From: alan.story@hertfordshire.gov.uk
Sent: 01 June 2018 11:48
To: Planning
Subject: Planning application 6/2018/1274/HOUSE - 16 Daffodil Close

District ref: 6/2018/1274/HOUSE

16 Daffodil Close
Hatfield
AL10 9FF

Erection of a two storey rear extension and conversion of garage into a habitable room.

PROPOSED GROUND FLOOR PLAN

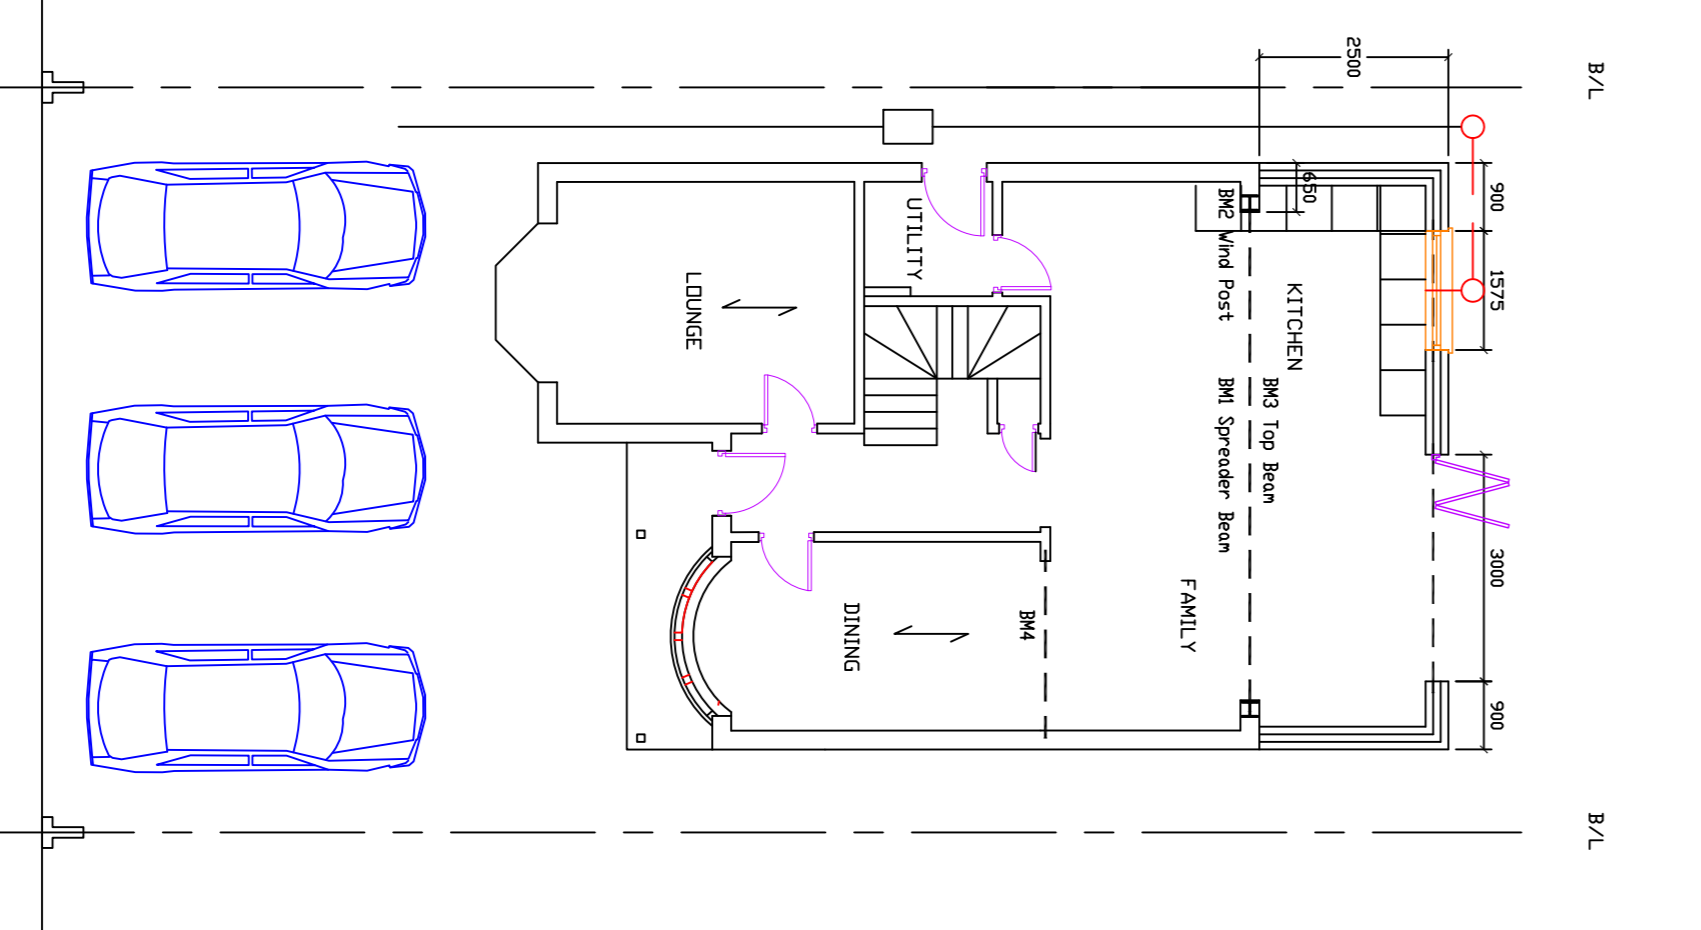
Development proposals represent loss of existing integral garage and creation of habitable space. Garage is shown to dimensions of 2.5m x 4.2m and reasonably would be inadequate (in depth) to accommodate many a modern vehicles. Research within Manual for Streets suggests that upto 50% of domestic garages are used for purposes other than the parking of a private vehicle. The loss of the garage may not represent loss of parking within the site. The existing dwelling is provided with front forecourt parking, and the nature of Daffodil Close at this point is such that kerbs are dropped for the entire length.

The dwelling would continue to enjoy a parking space to front for upto 3 vehicles. It is the Highway Authority view that the garage unlikely accommodates a parked vehicle and therefore its' loss shall have no appreciable impact on local highway conditions

The loss of garage is unlikely to result in parking being displaced onto the highway and unlikely to have a material impact on the free and safe flow of the highway network. Accordingly I present no objection to the proposals.
